**A57 Link Roads**

**TR010034**

**9.88 Applicant's comments on Deadline 11  
submissions**

May 2022

- LEGEND**
- MODELLED QUALIFYING FEATURES AND PUBLIC ACCESS
  - DEFRA PCM LINKS COINCIDING WITH ROADS MEETING THE DMRB LA105 TRAFFIC SCREENING CRITERIA
  - ROADS MEETING DMRB LA105 TRAFFIC SCREENING CRITERIA

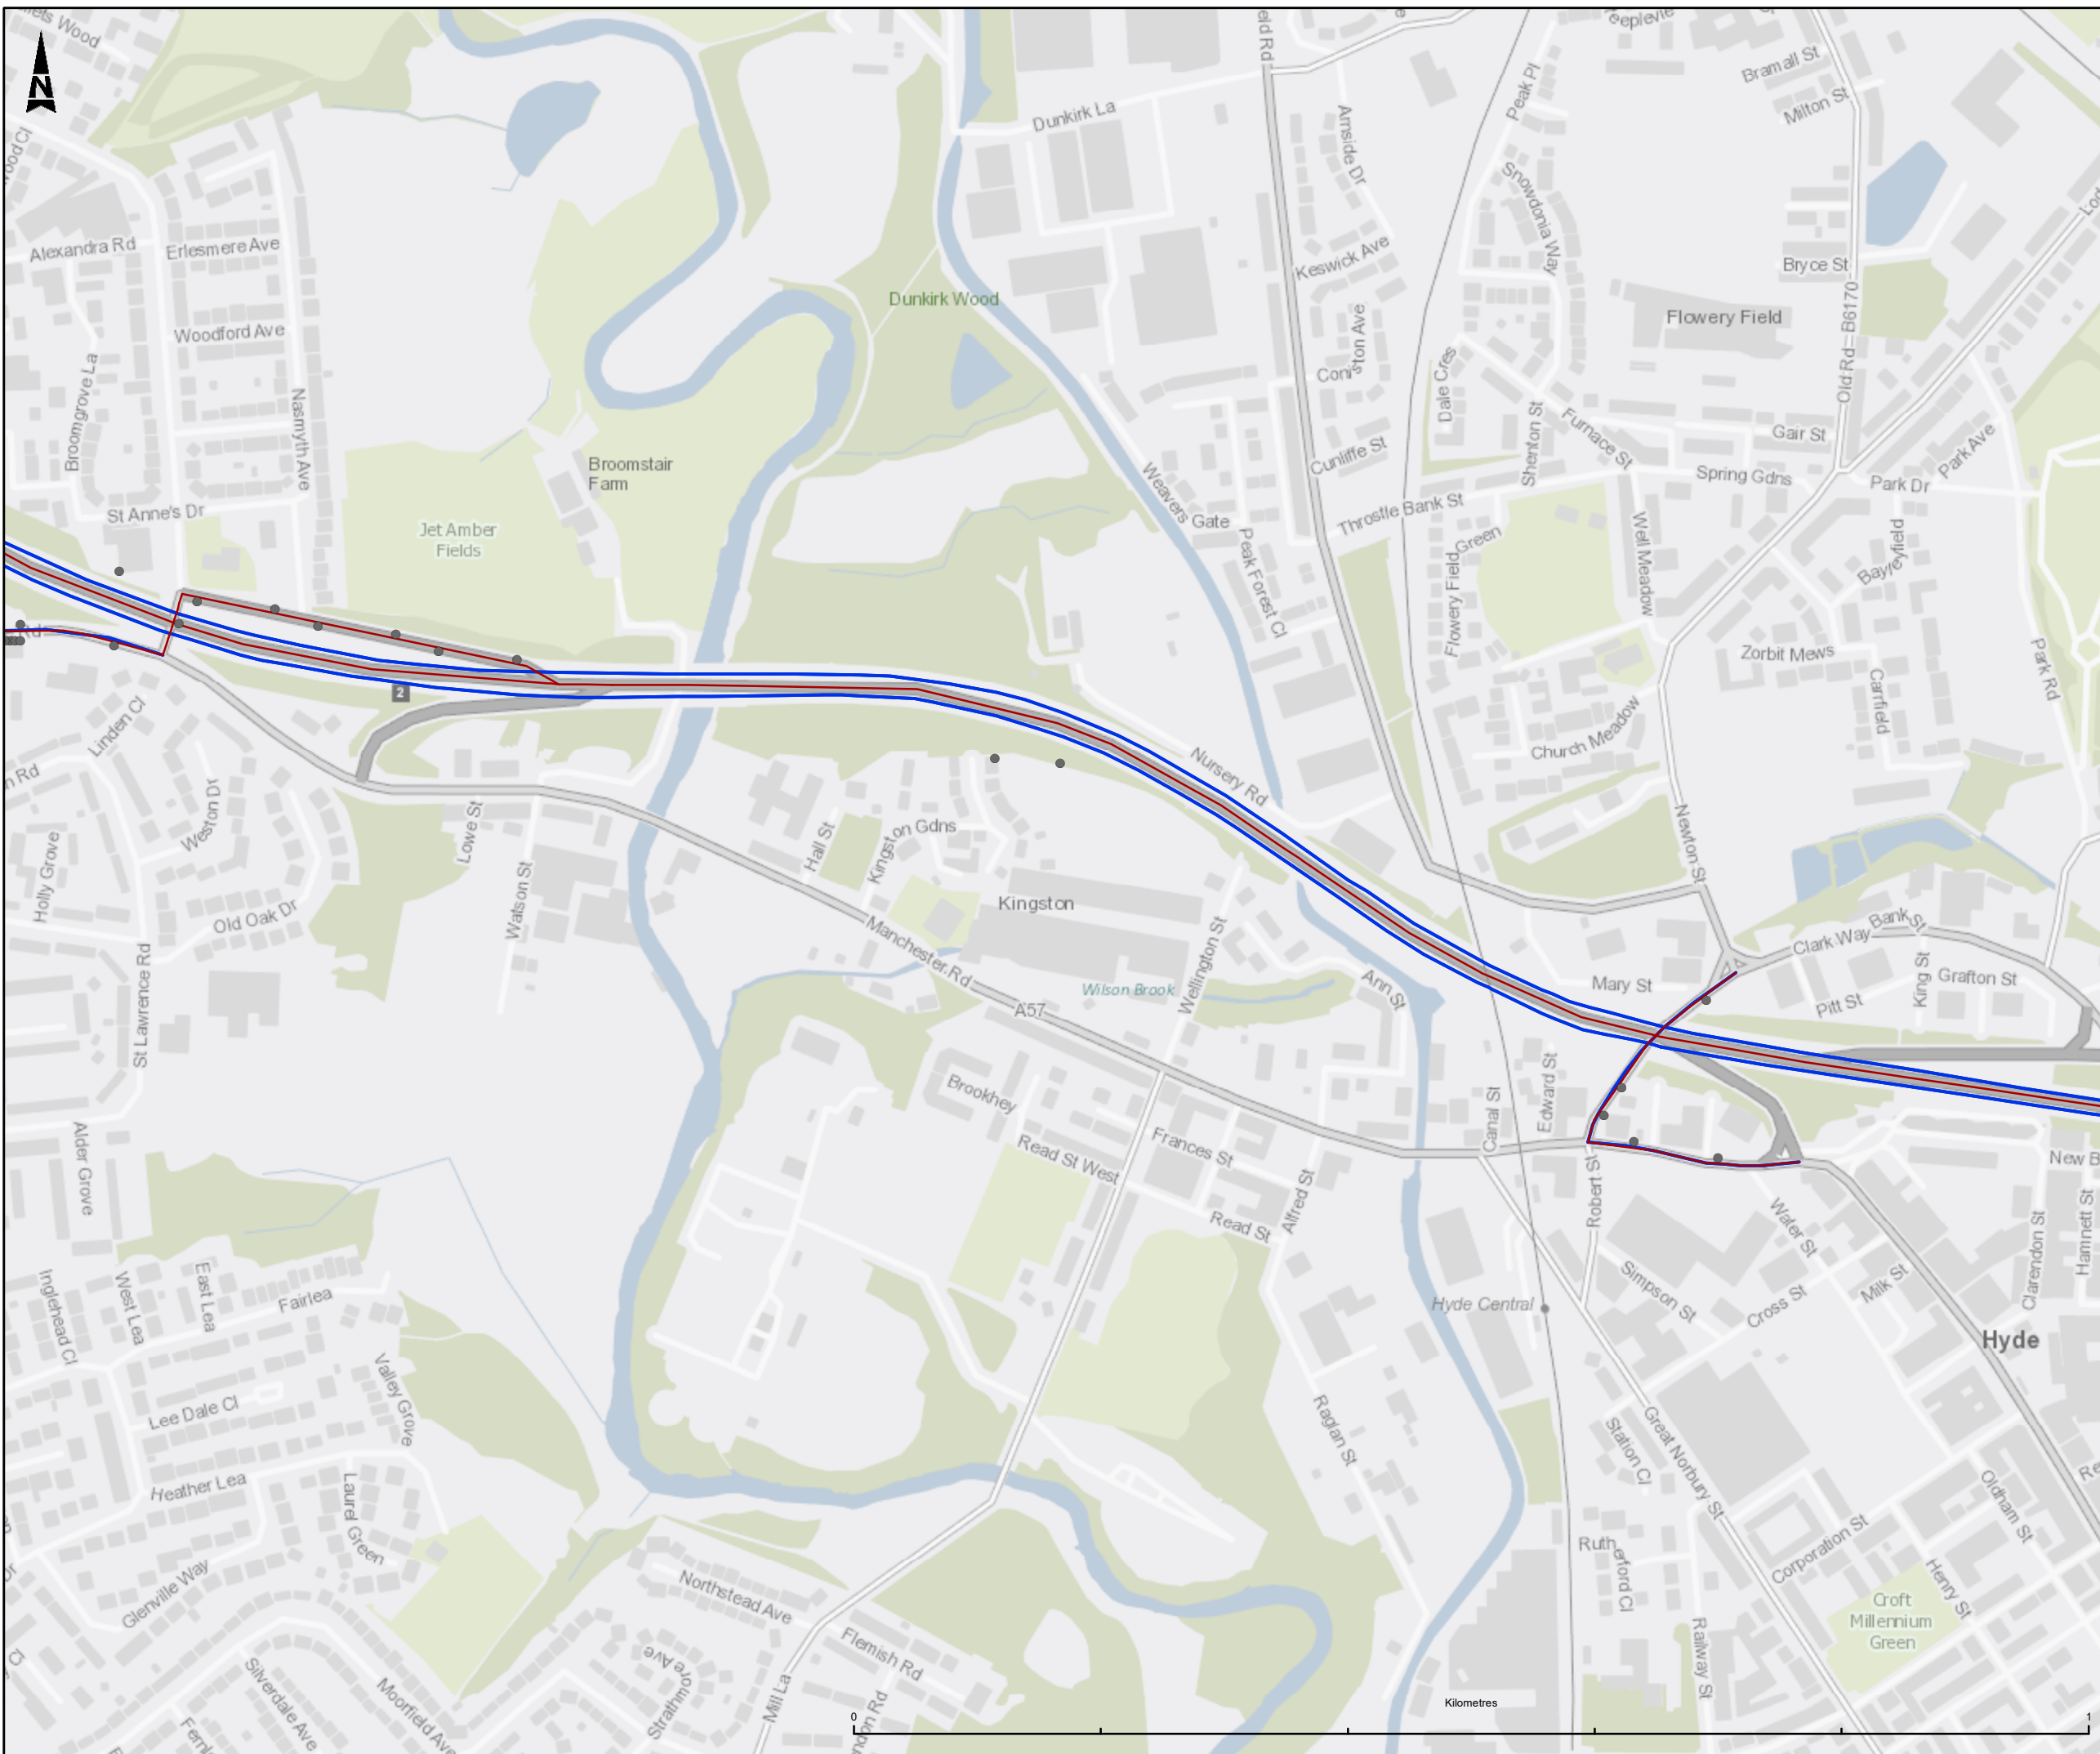
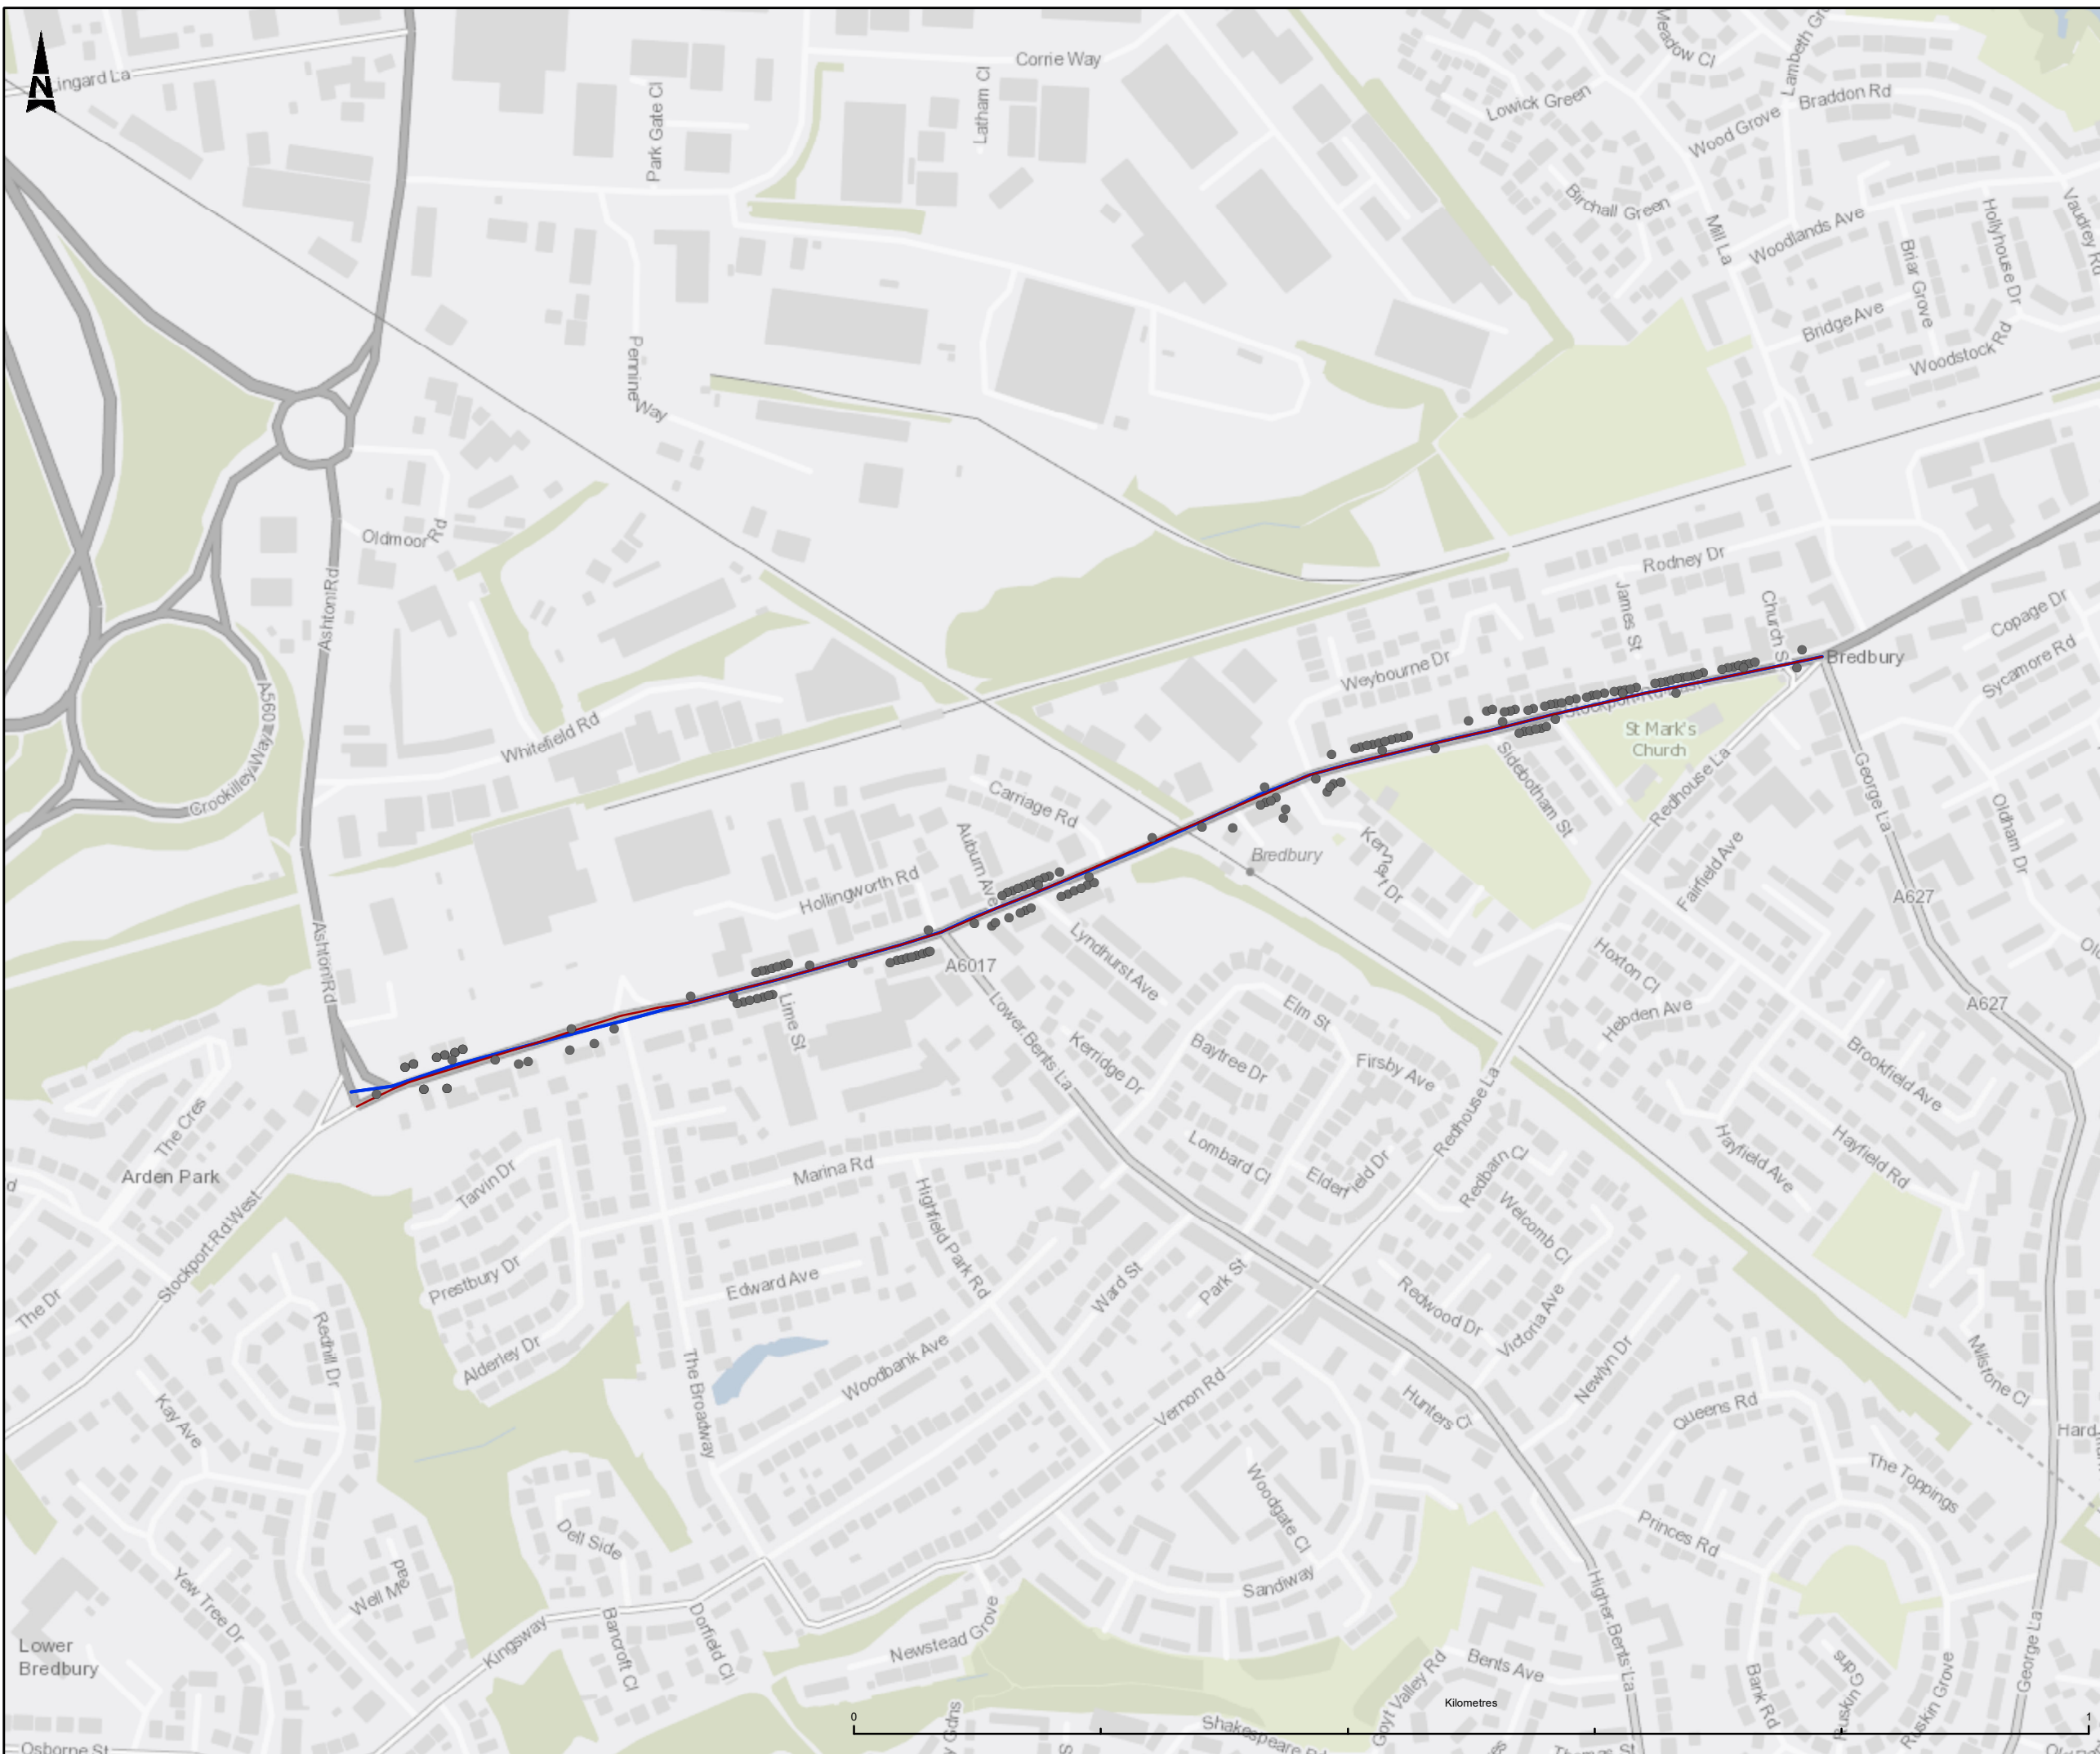
Reference	IP Issue	NH Response
9.88.4	<ul style="list-style-type: none"> <li>human health receptors on the A57 in Brookfield Identification of the receptors (figure 5.4) used in the compliance risk assessment (using LAQM “conservative” forecast”) indicated that “large” change at some of the receptors along Brookfield. However, it also highlighted that some of these were human health receptors that had not been included as receptors in the (less conservative) primary human health AQ assessment (DMRB LA 105). Therefore, HPBC have requested that these receptors are also assessed in accordance with the DMRB LA 105 . Following further discussion and clarification (virtual meeting held 8th April 2022) it was agreed that a sensitivity test will be undertaken to identify the air quality impact at relevant qualifying feature receptors located adjacent to the A57 Brookfield under the DMRB LA 105 human health assessment methodology (to be submitted by National Highways at deadline 11 – ref. TR010034/EXAM/9.86) Results from the updated air quality assessment updated DMRB LA 105 indicated a “Large increase” in NO2 DS compared to DM in 2025, at locations along Wooley Bridge with 1 location exceeding the AQO (40ug/m3) as a result of the scheme.</li> </ul>	<p>The Applicant’s position is provided in the Deadline 12 submission of the final Statement of Common Ground with High Peak Borough Council (TR010034/APP/8.3(3)). The supplementary air quality assessment for Brookfield is provided in REP11-011. It states that, [for receptors exceeding air quality standards] given the number of receptors (75 receptors) that experience a decrease in concentrations with the Scheme, it is still considered that this outweighs the one receptor with a ‘small’ increase in concentration and one receptor with a ‘large’ increase in concentration with the Scheme. Overall, as reported in the ES, the impact of the Scheme is an improvement in air quality for human health receptors and there is not a significant adverse effect due to the Scheme (paragraph 6.1.2 of REP11-011).</p>
